**WEST SUSSEX COUNTY COUNCIL
INFRASTRUCTURE CONSULTATION**

SUBJECT: LU/18/11-Erection of 2 x 3 bedroom town houses

R/O 27-29B, Surrey Street, Littlehampton, West Sussex, BN17 5BD

BLOCK PLAN

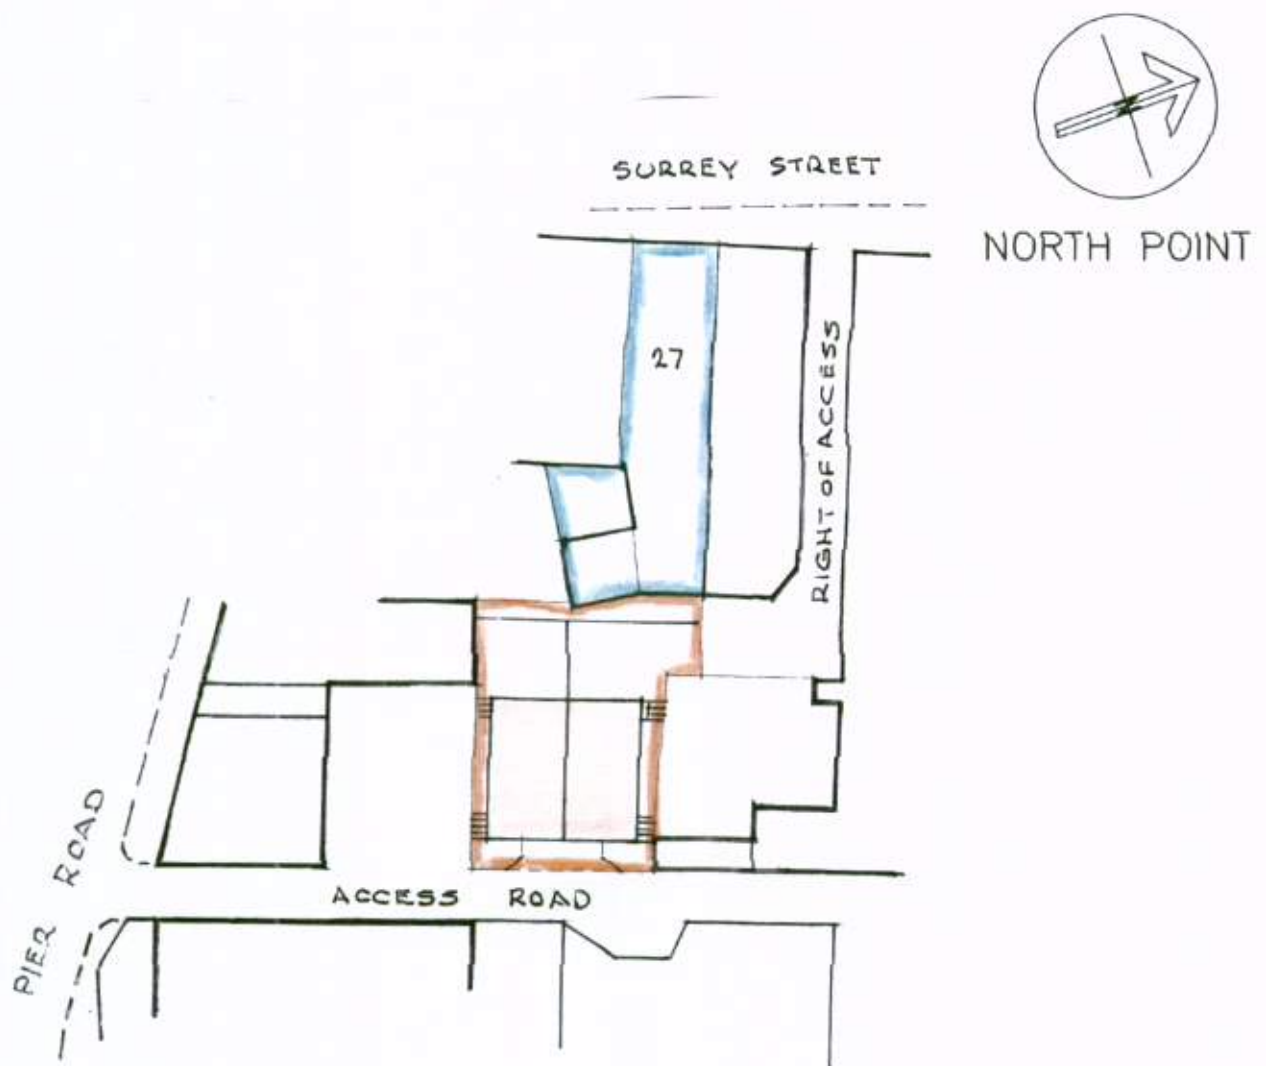
Based on the latest WSCC car parking standards the application does not include sufficient space for the expected number of vehicles at the development. The applicant should demonstrate that the total number of parking spaces available at the development, either through provision of off-street parking spaces, on-street spaces (on or off the public highway) or a combination of both, is sufficient to accommodate the expected number of vehicles at the development. If some or all vehicles are expected to park on the public highway, then the applicant will need to demonstrate, using a car parking capacity survey, that there is sufficient available space to accommodate the expected number of vehicles. Guidance on the County Council's approach to residential parking and car parking capacity surveys can be found on our website.
